Planning Application Ref: **AW/323/18/T**

Location: **2 The Lawn, Aldwick PO21 4XJ**

Description of works: **Fell & remove 1No. Hornbeam tree & reduce by 5m over highway & 2m from boundary 1No. Hornbeam tree**

2 THE LAWN

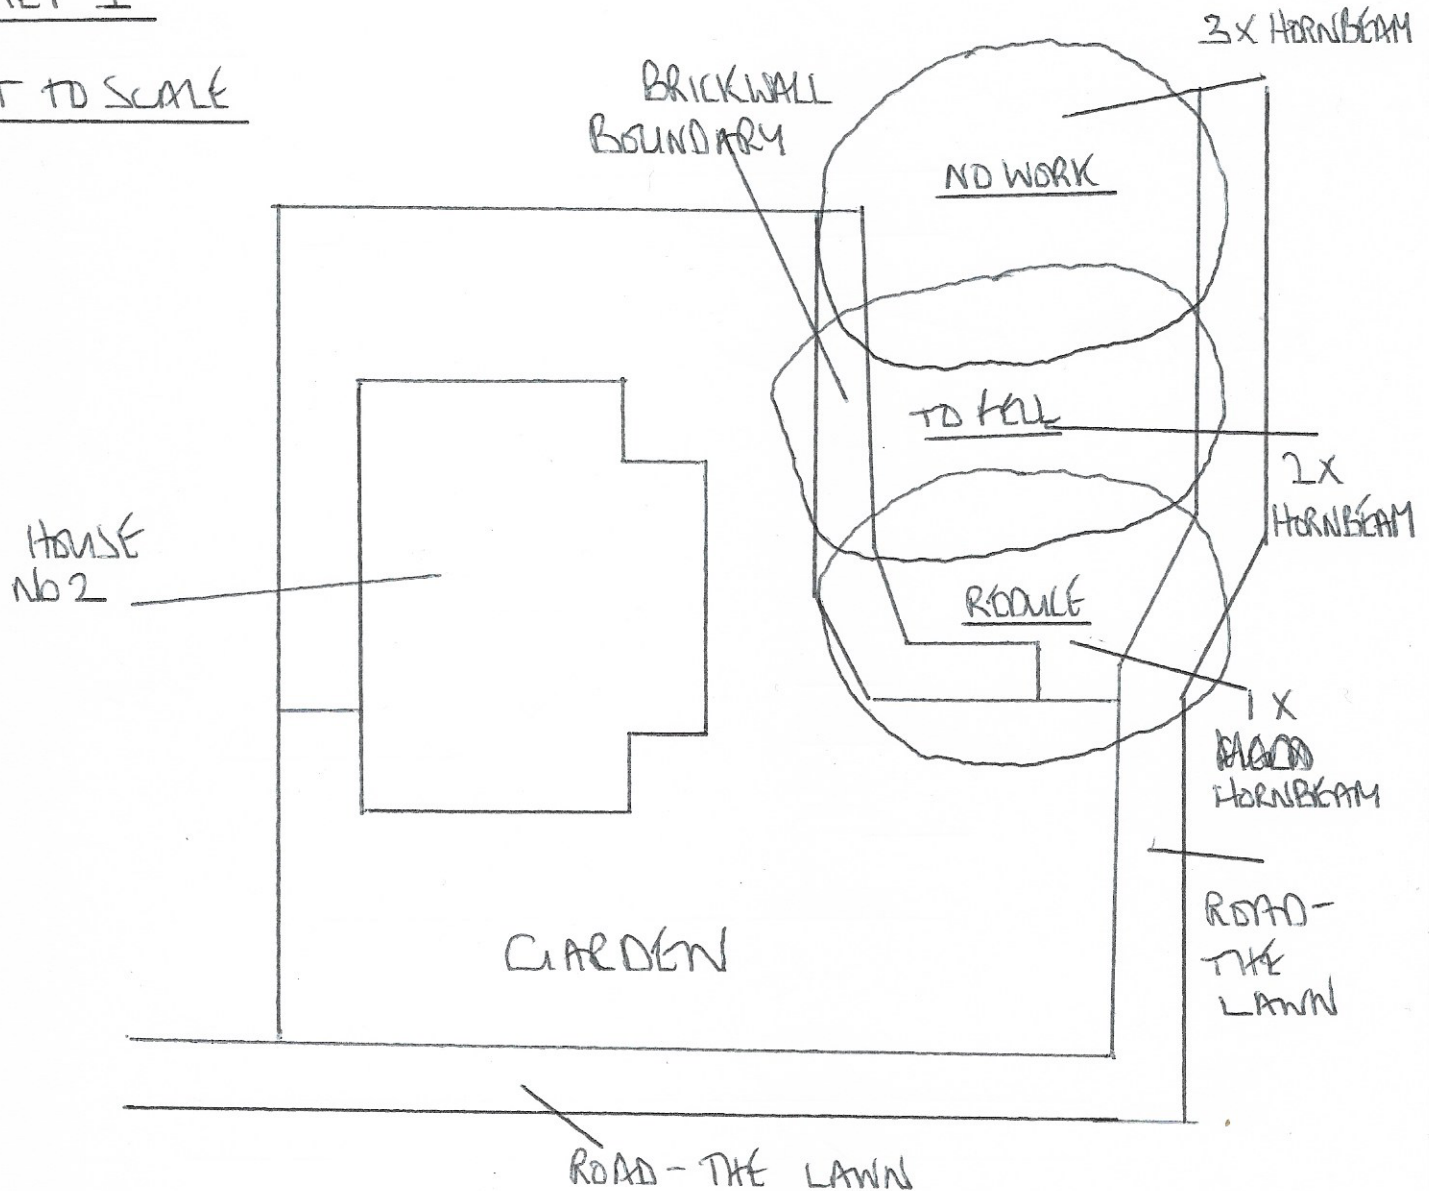
- It is proposed to undertake the following work to the southernmost tree: 1. Crown lift to achieve maximum 5metres overhead clearance above the carriageway. 2. Reduce back lateral extent (west aspect only) by maximum 2metres.

- It is proposed to fell the middle tree to ground level. This tree appears to be under considerable physiological distress arising from probable fungal infection low in the main stem/roots, with associated high deadwood content across the upper crown.

- The northernmost tree has not been proposed for any pruning work

- I recommend **CONSENT** for this application, subject to the following conditions:

- Where whole branches are to be removed and final cuts made close to the trunk or branch union they are to be made as shown in Figure 2 of BS3998:2010
- Where branches are to be shortened back the final cuts are to be made at the correct angle shown in BS3998:2010 and adjacent to a live bud or lateral.
